Case ref: EN0110020

Application by Whitestone Net Zero Ltd for an order granting development consent for the Whitestone Solar Farm

Advice following issue of decision to accept the application for examination

TITLE:
Works Plan
Sheet 20 of 29
Whitestone Solar Farm
Regulation 5(2)(j)

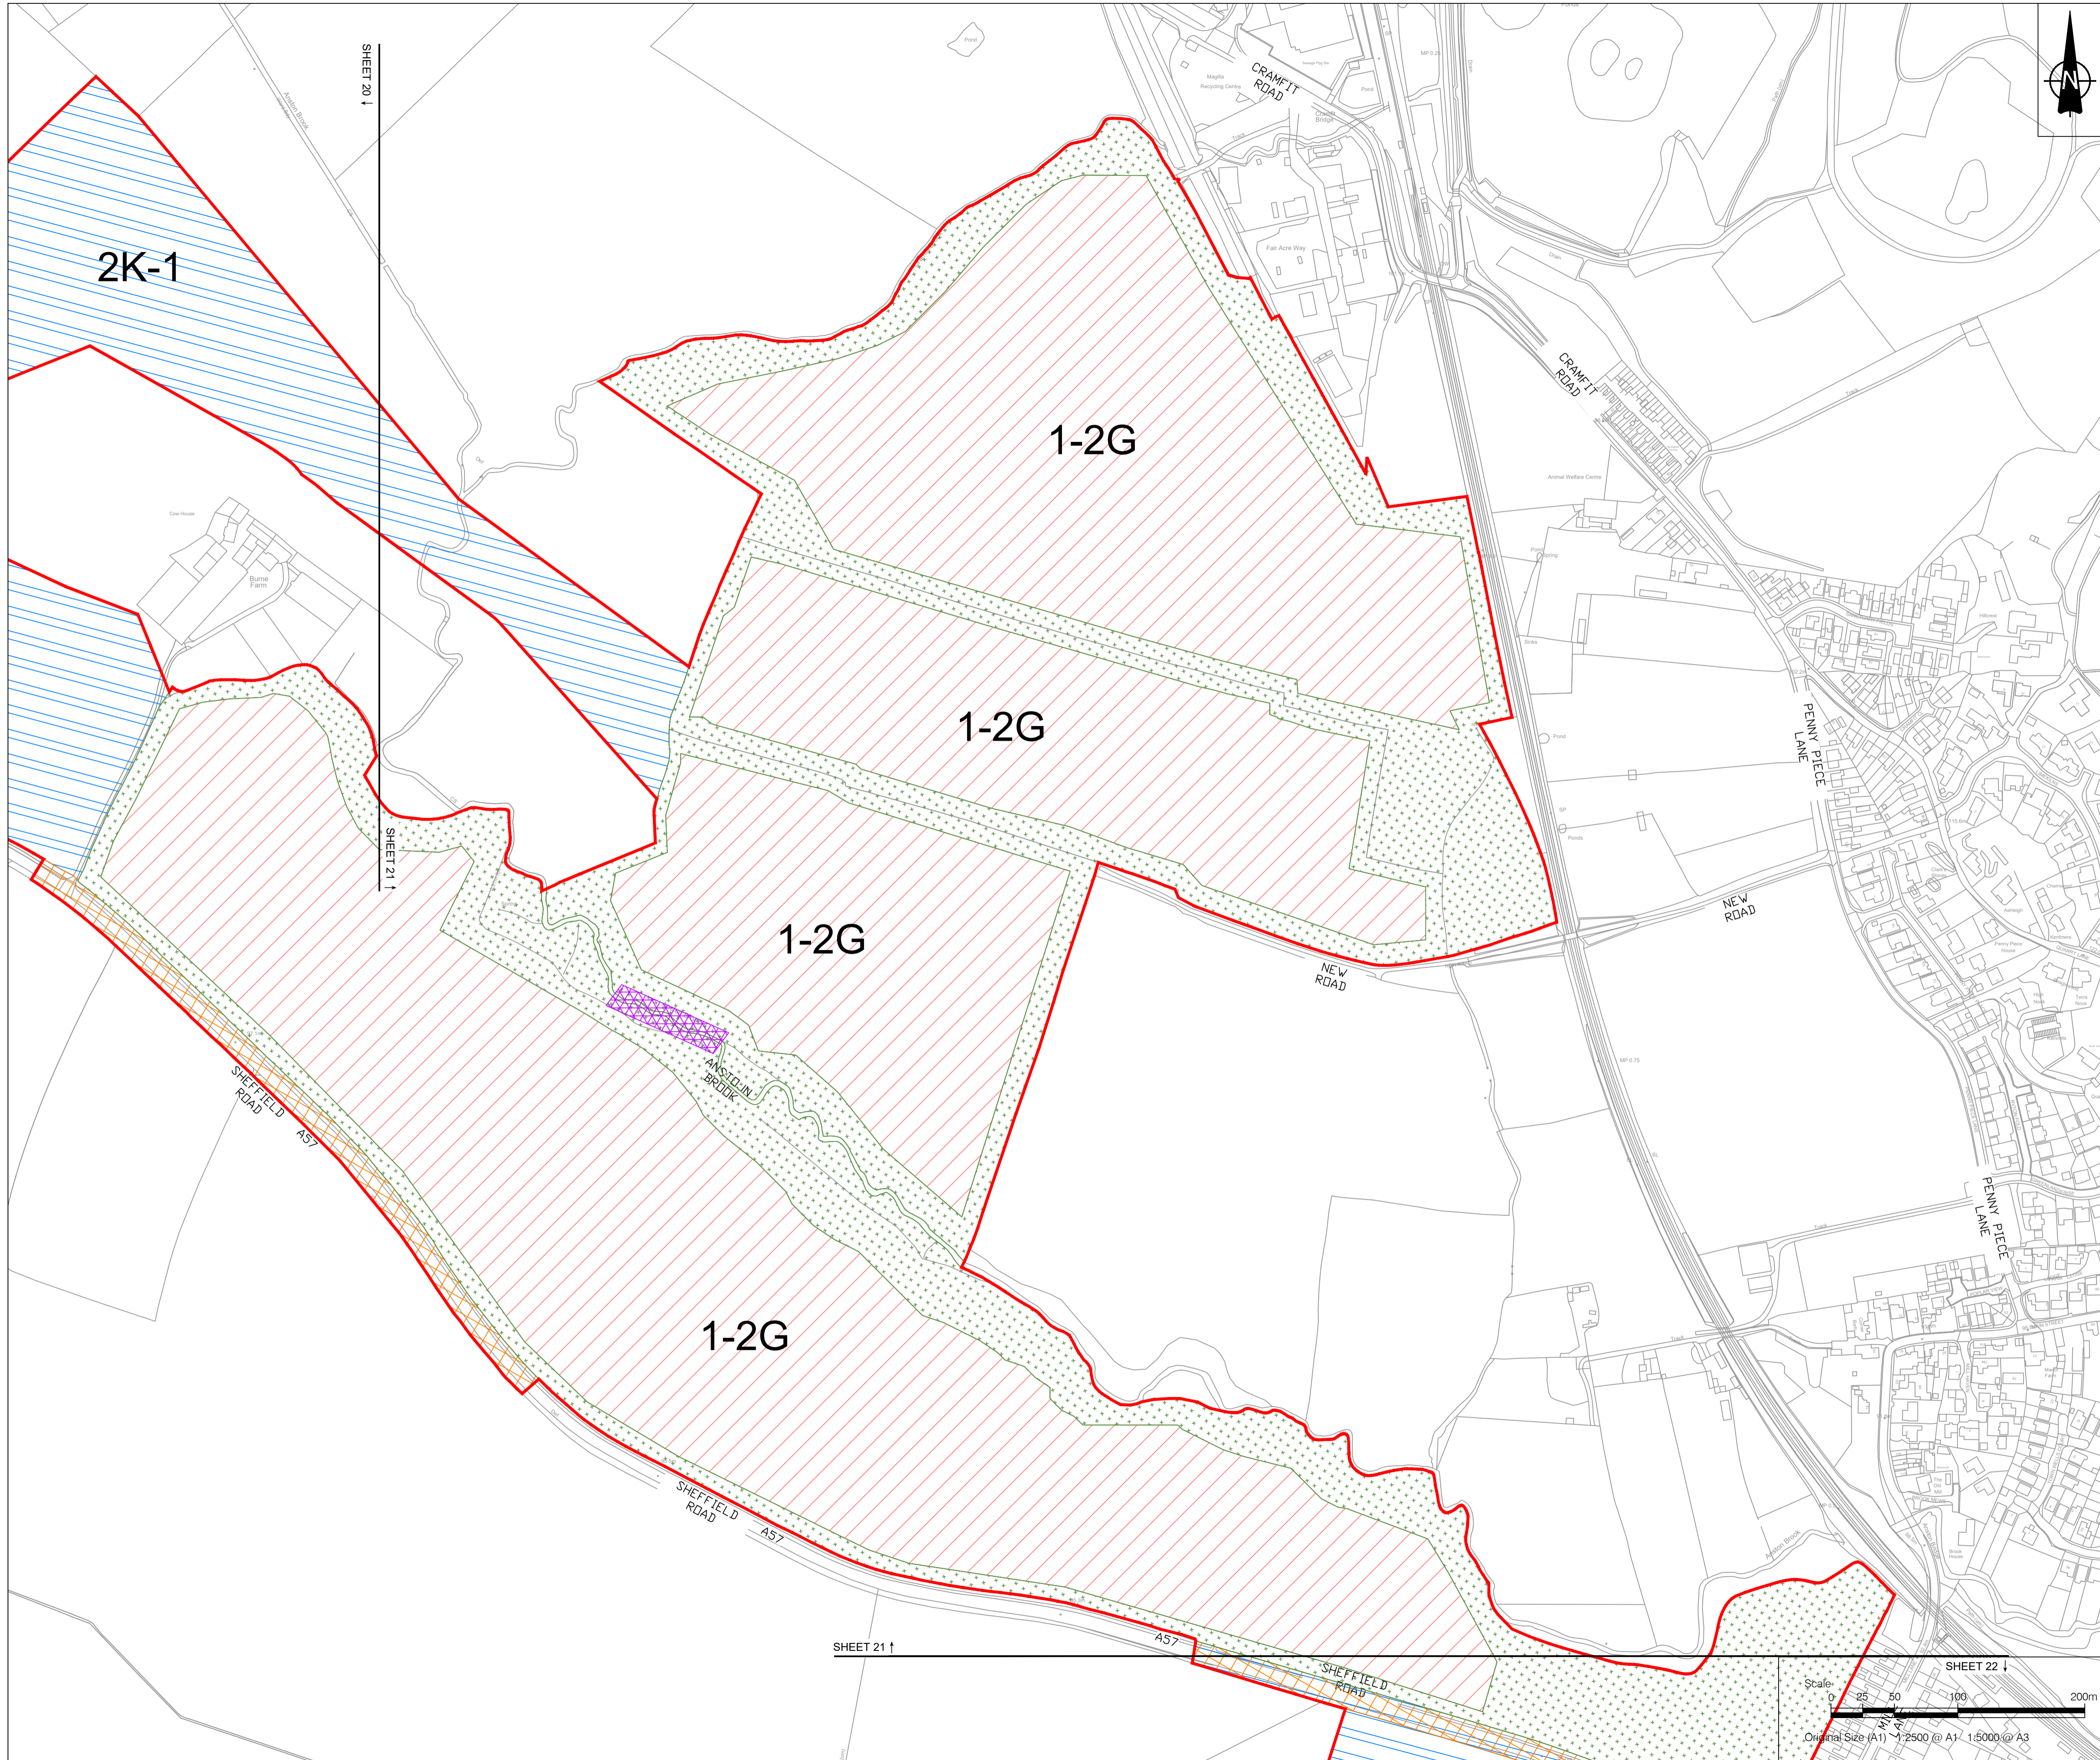
Within the Works Plans (Doc 2.3) the applicant should consider if it would be useful to have the works descriptions within the legend. On sheet 20 works '1-2F' needs to be checked to see if labelling is correct. Plots 4-11, 4-10, 4-9, 4-8, 4-7, 4-6 as identified in the Land Plan seem to be missing; if these are needed, they will need inserting.

SCALE: 1:2500	SHEET: Sheet 9 of 29
SIZE: A1	REVISION: P02

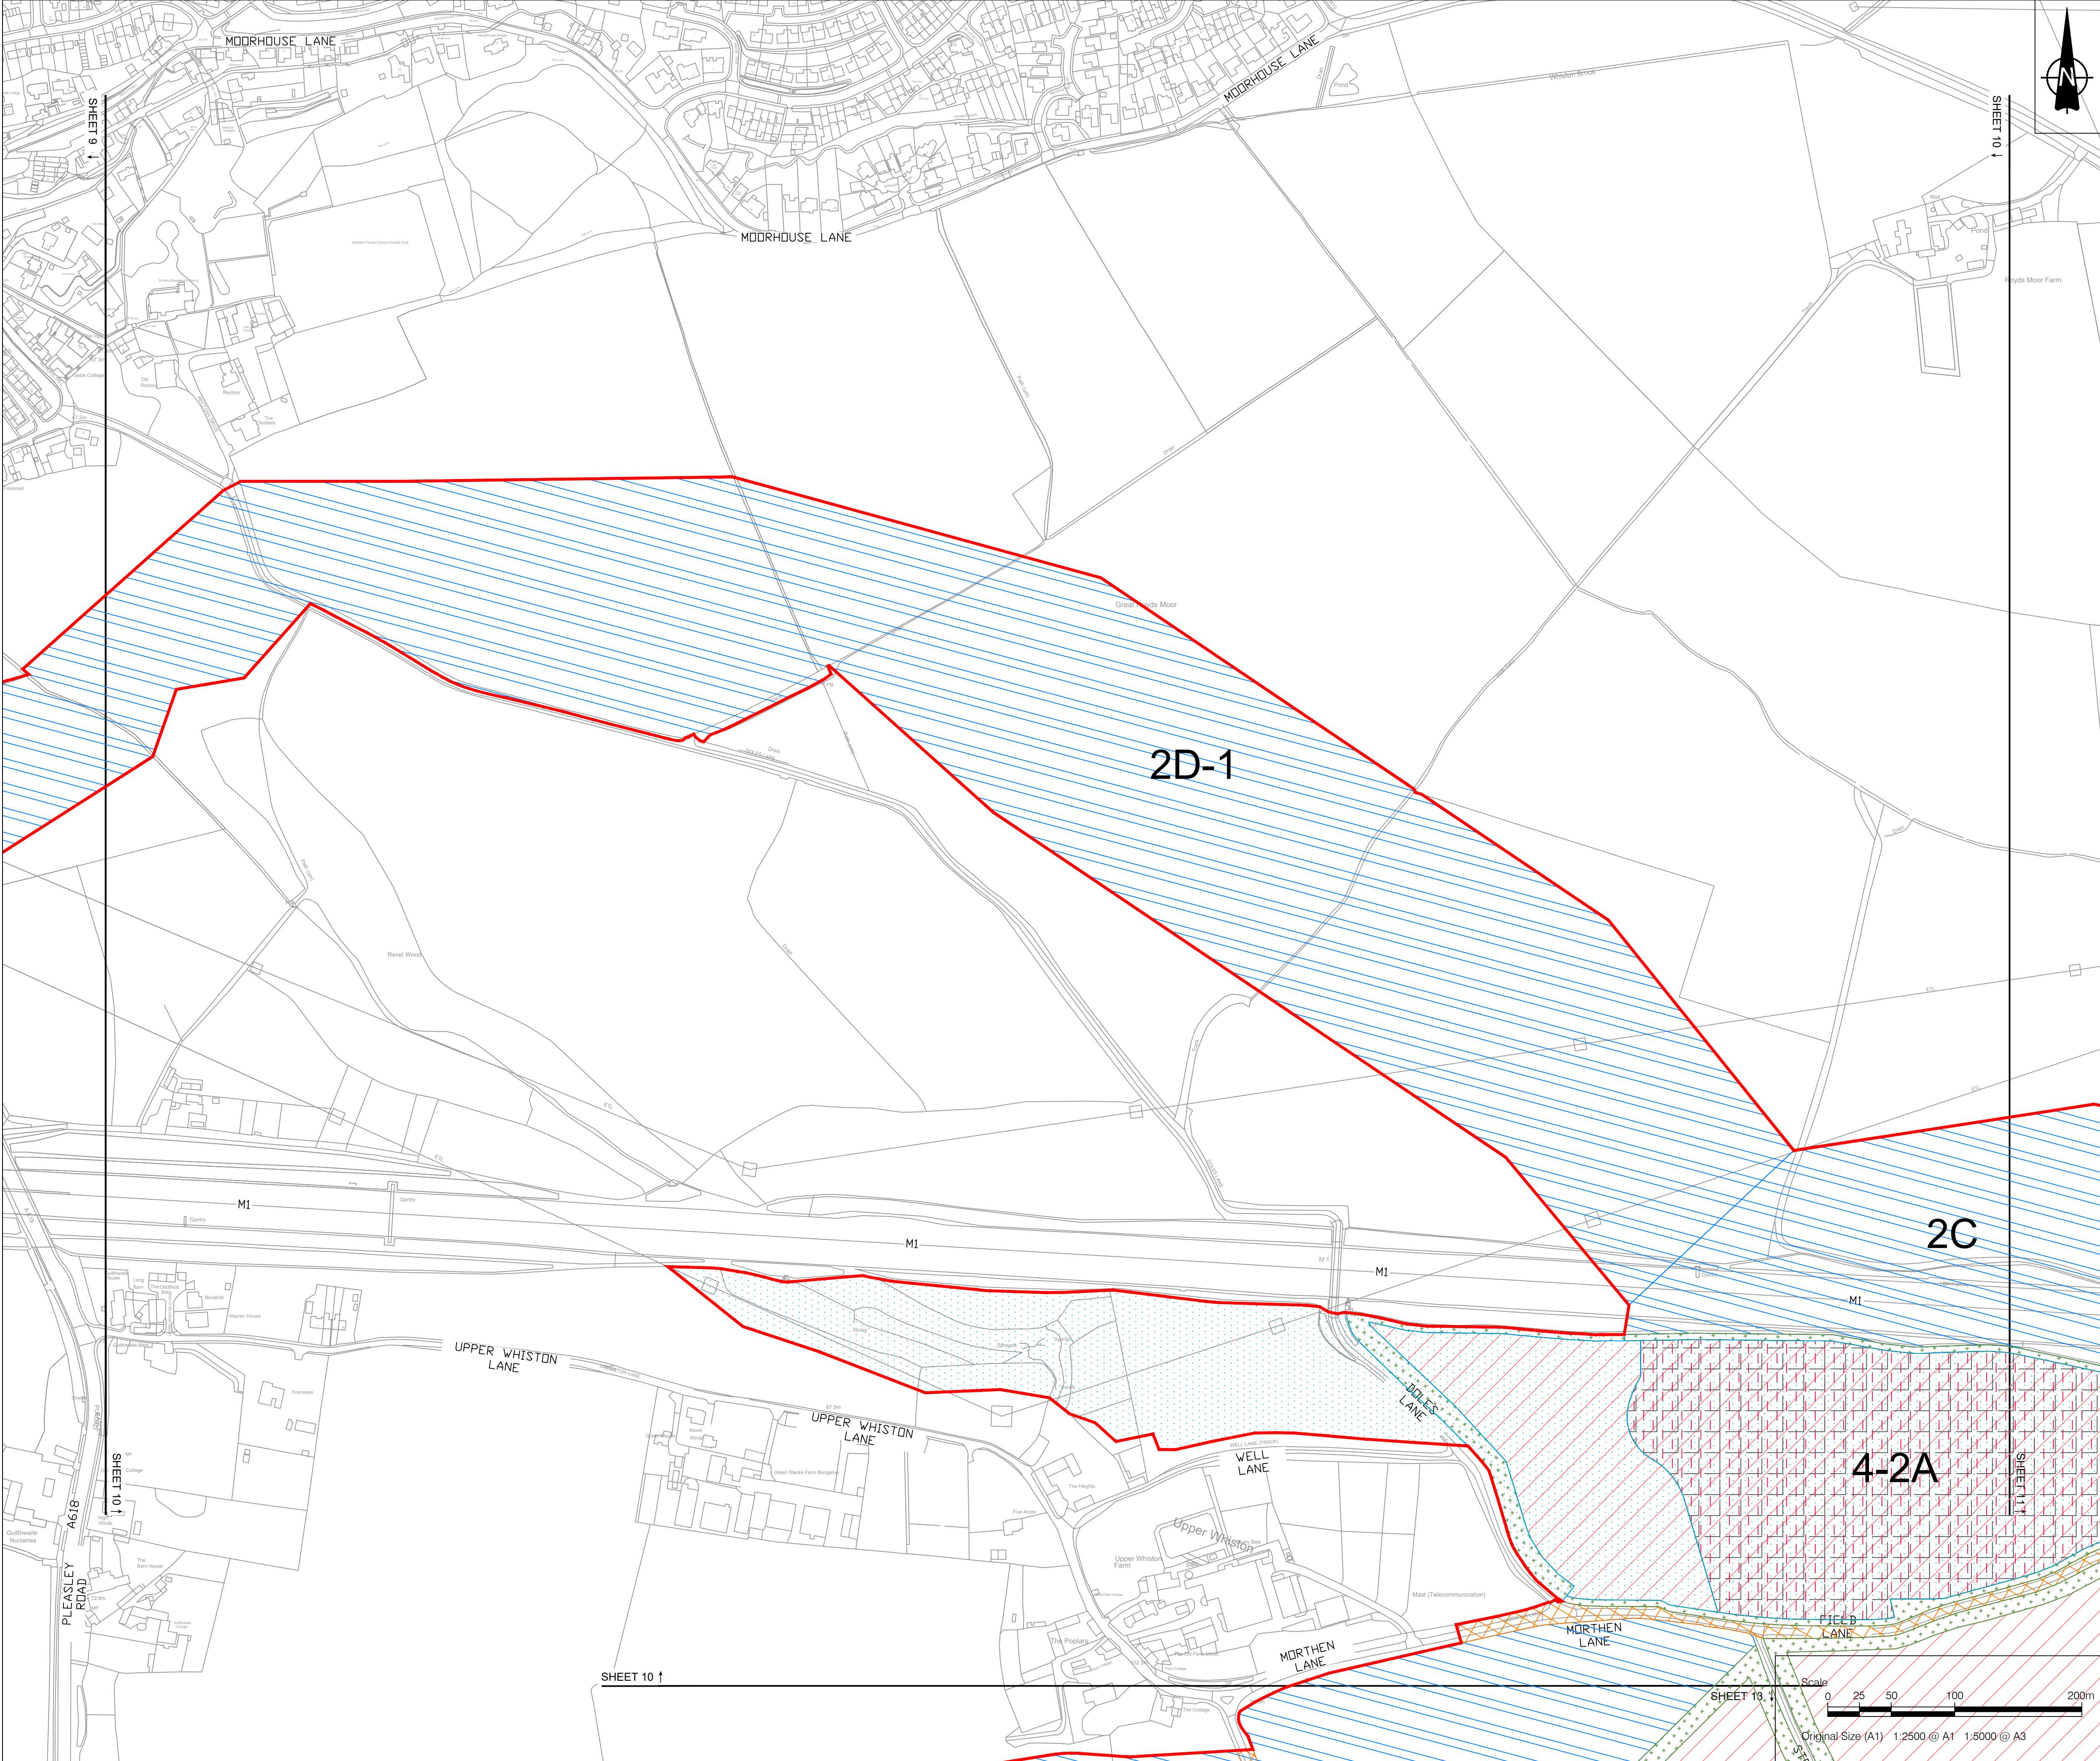
In the Grid Connection Statement, (Doc 7.1) paragraph 6.1.3 says that the new Long Lane substation is shown on Sheet 9 of the Works Plans however, this is not shown on the Works Plans.
